Case Officer: Hannah Kersley
Reference: AW/408/21/T
Location: 9 Hornbeam Close, Aldwick, PO21 4AH
Proposal: Crown reduction of 1no. sycamore tree to height 17m and spread 6.5m
Reasons given: Restricts light and too big for a small garden. Fear of damage from falling branches

BLOCK PLAN
TREE CANOPY REDUCTION

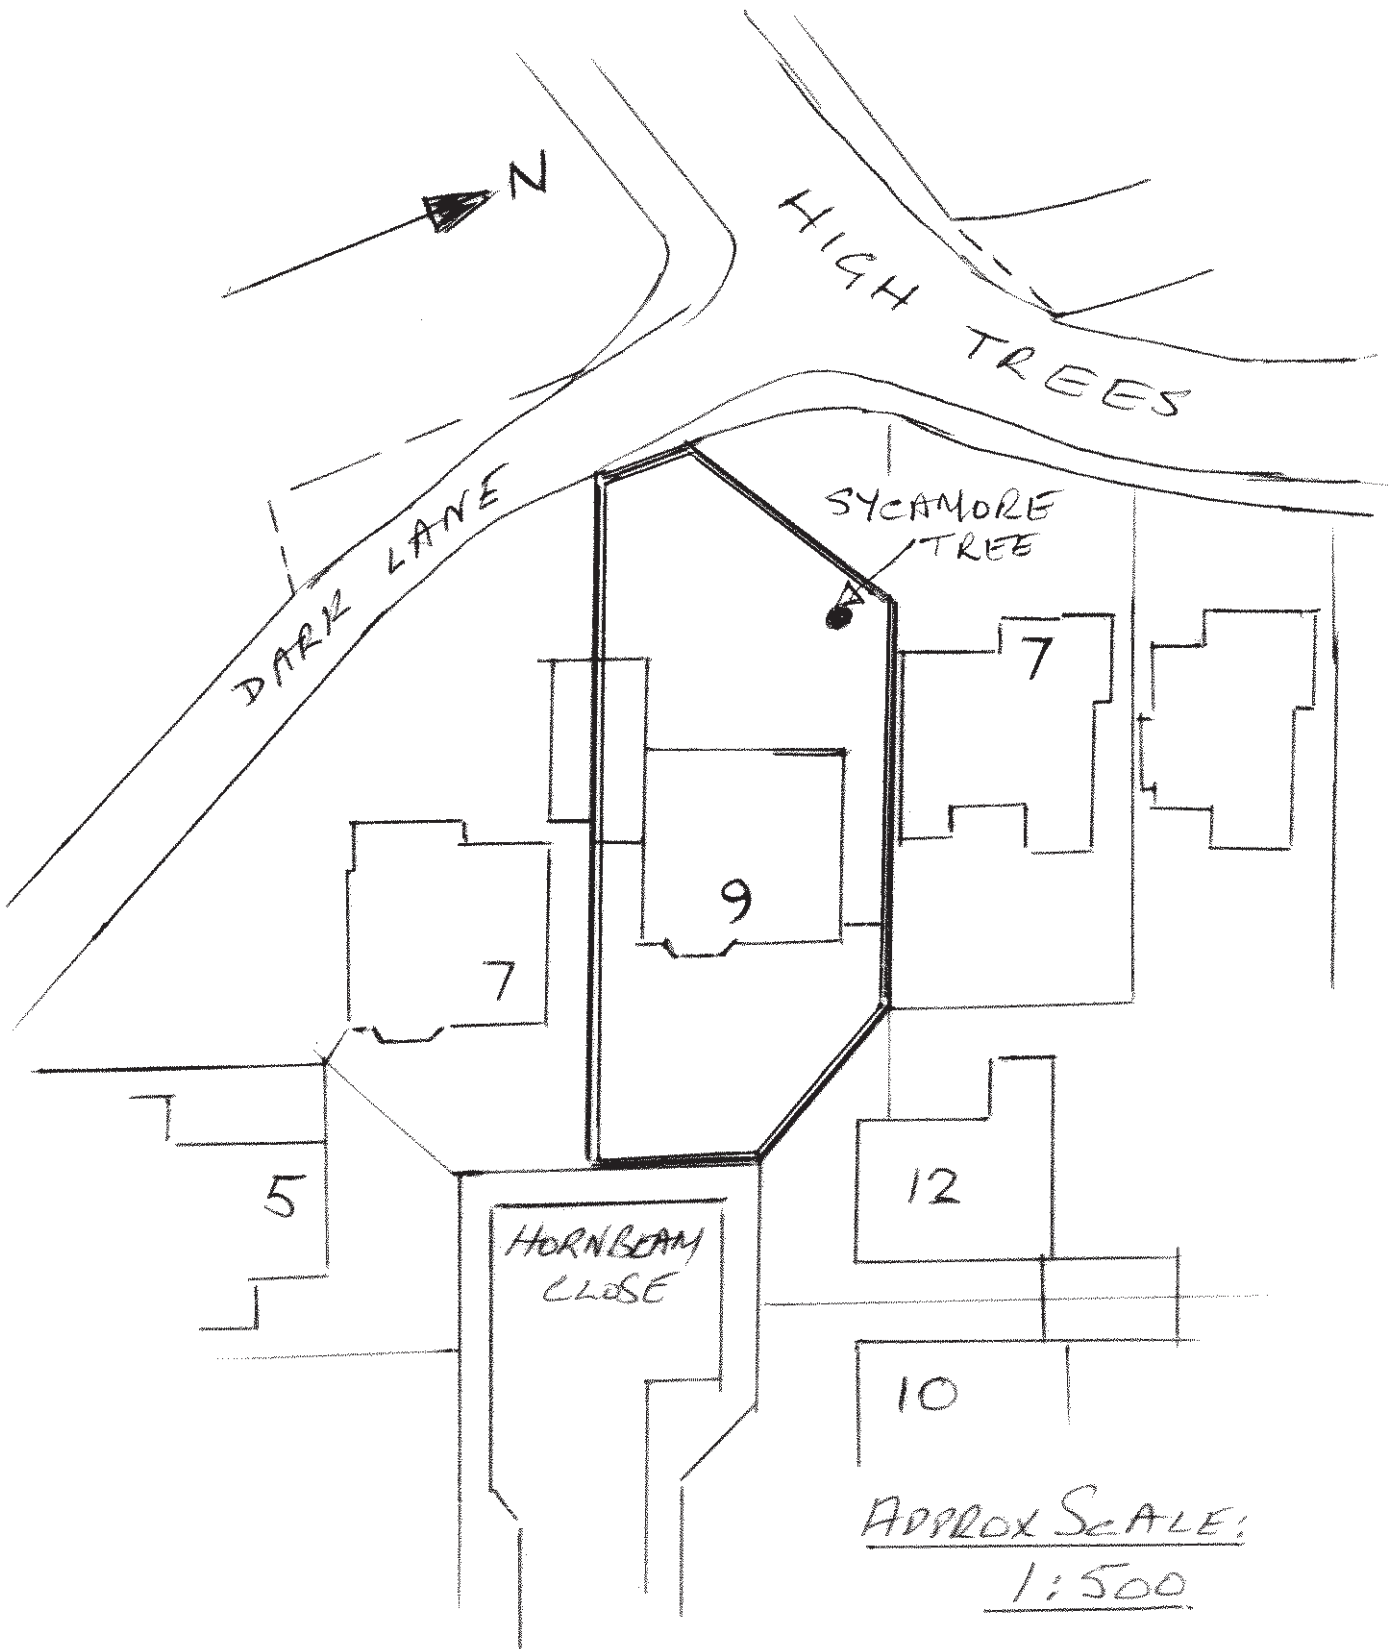
- Outwardly and from a distance (roadside) this tree appears to be in a fine physiological state and assumed to be so in the absence of any evidence provided to the contrary.
- It is visible from surrounding properties and to users of the public highway (footway and carriageway) so has public amenity value.
- Outwardly and from a distance it appears to be in a fine physiological state. It grows at the rear of the property and can be seen from neighbouring dwellings but has only limited visibility from publicly accessible land.
- Repeat operations such as now being asked for by the applicant will be necessary throughout the remaining lifespan of this tree, to achieve a reasonable degree of structural integrity appropriate for its location.

- The proposal to reduce overall height and spread with a view to restricting its growth is justified and consistent with previous works approved by the Local Planning Authority.
- While a temporary loss of aesthetic value is inevitable, satisfactory canopy renewal and recovery should occur if the work is undertaken to a high standard and at an appropriate time of year.

Part a) Where whole branches are to be removed and final cuts made close to the trunk or branch union they are to be made as shown in Figure 2 of BS3998:2010

Part b) Where branches are to be shortened back the final cuts are to be made at the correct angle shown in BS3998:2010 and adjacent to a live bud or lateral.

Part c) The removal of crown material which has developed since the last operation (c2014) must be done sympathetically and with respect to established 'knuckles' so as not to extend beyond the point of origin.
